RE WORTLEY VILLAGE PLAN

Following our site meeting at Wortley Village on 20th October 2016. Please find attached the following drawings revised as per our onsite discussions.

707 03-03 P1

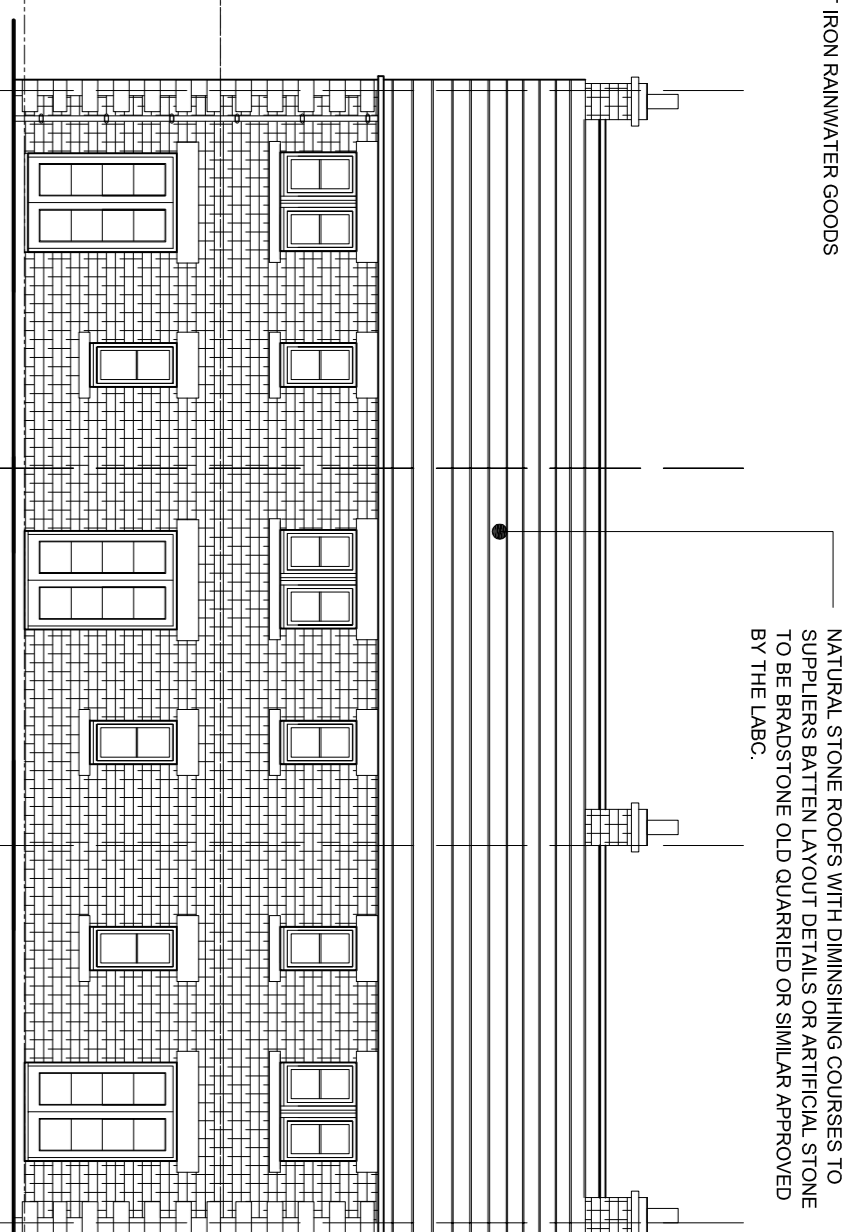
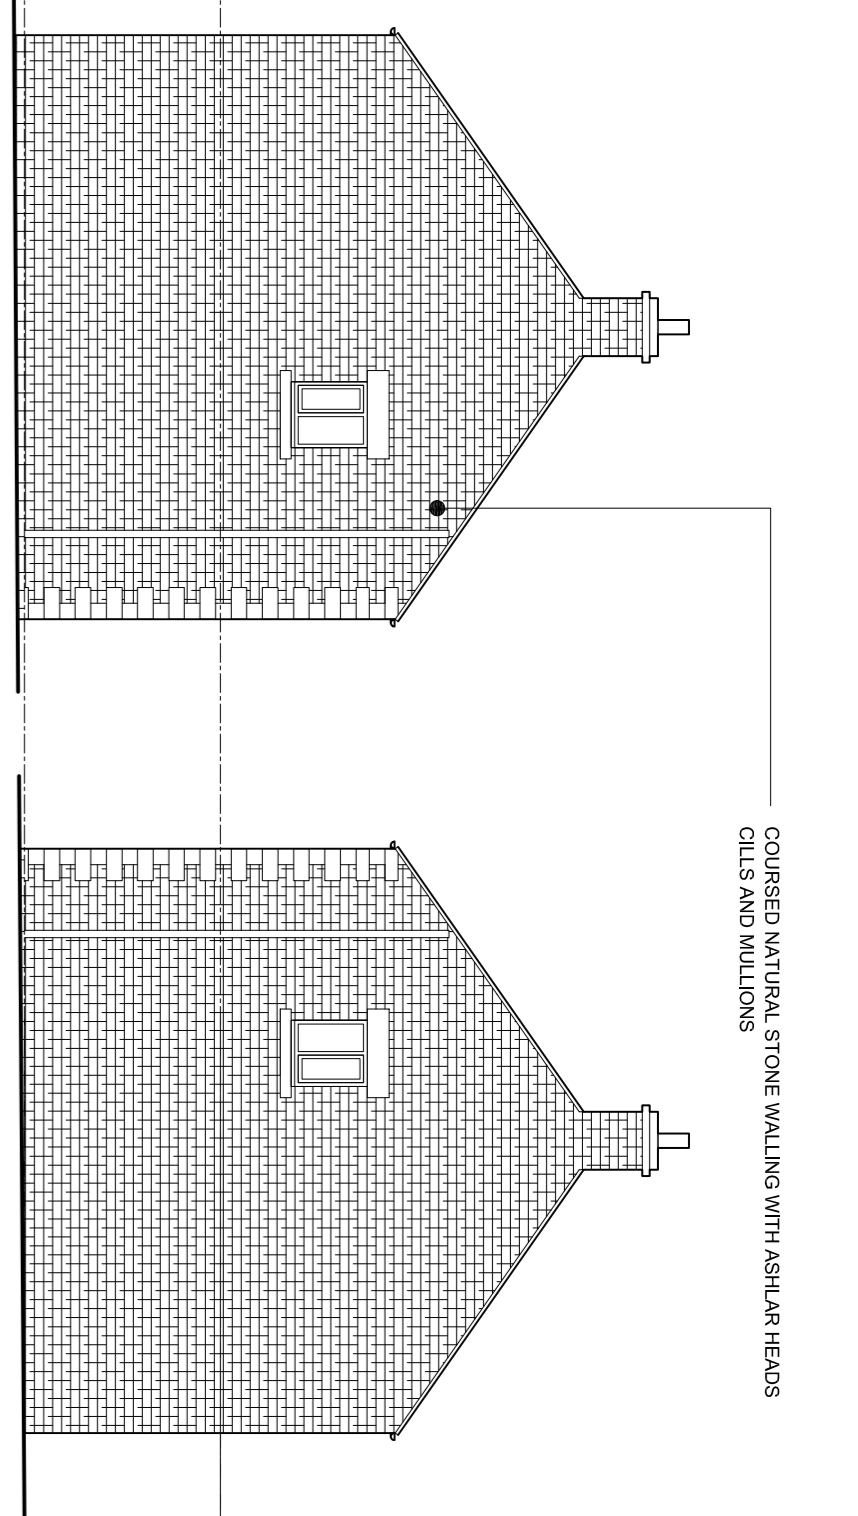
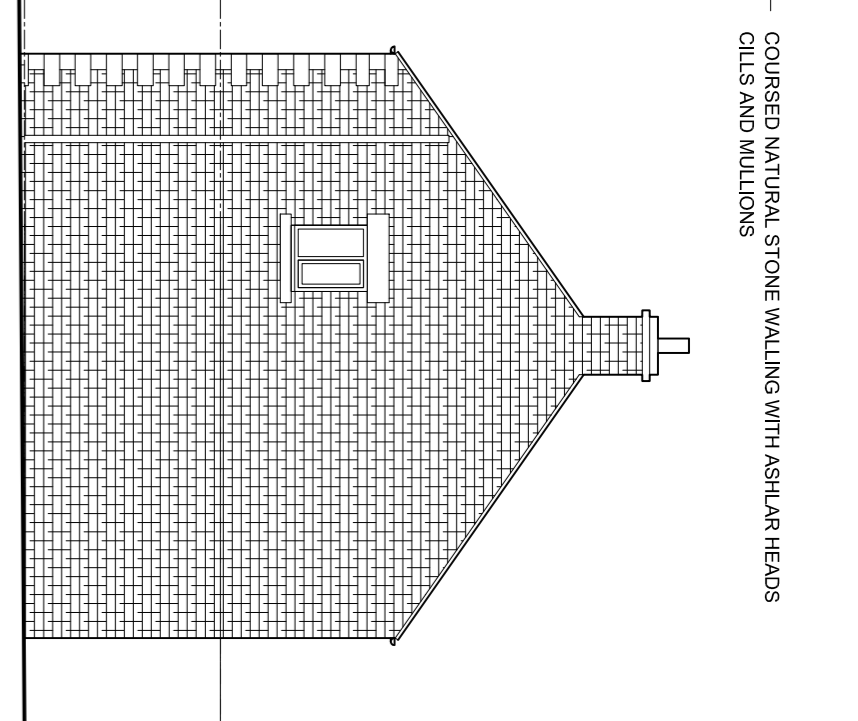
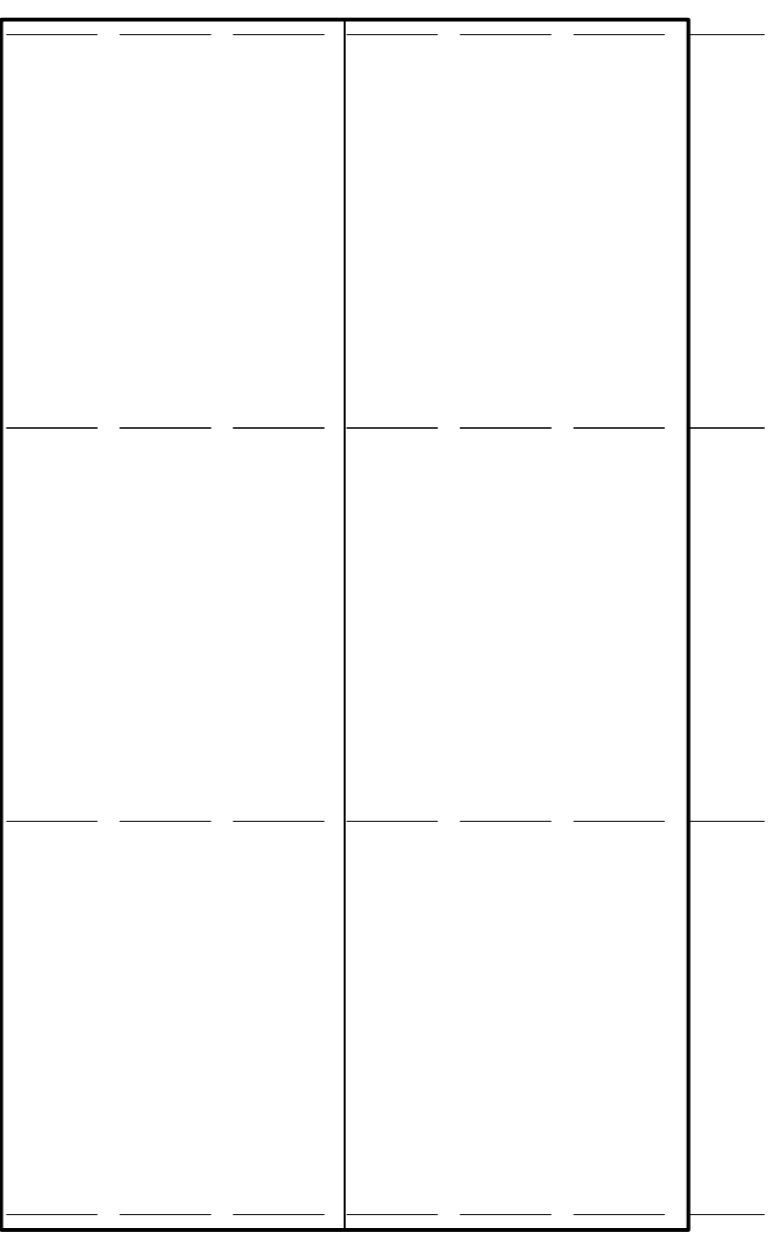
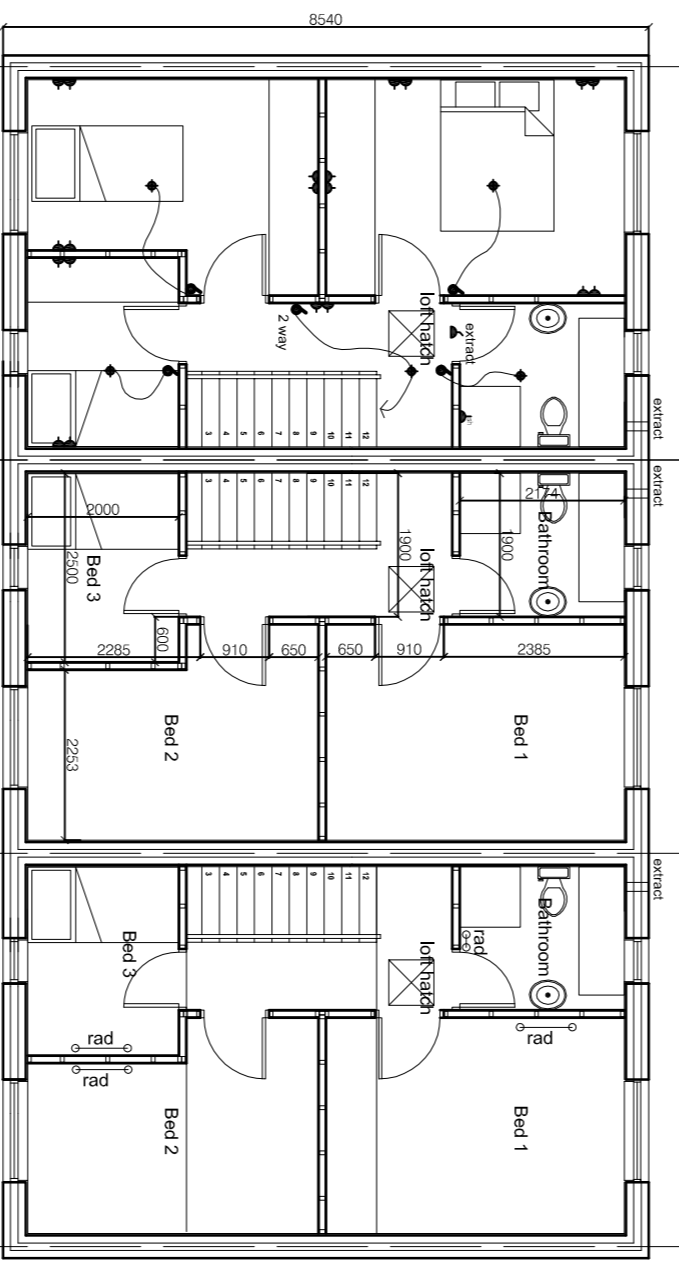
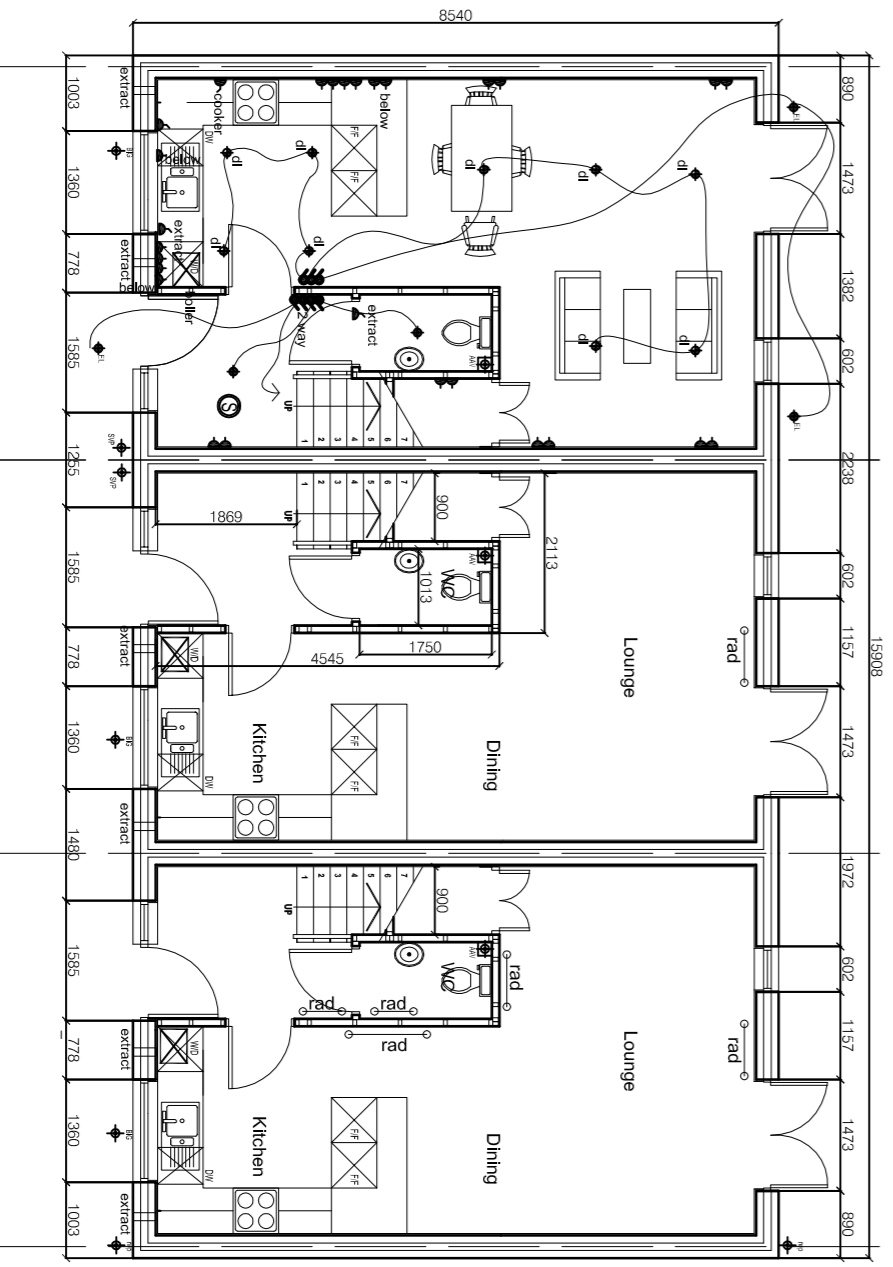
- 707-02-02-P2** Revised to confirm gutter details and roofing materials.
- 707-03-02-P2** Revised to confirm gutter details.
- 707-03-03-P1** Revised to confirm gutter details.
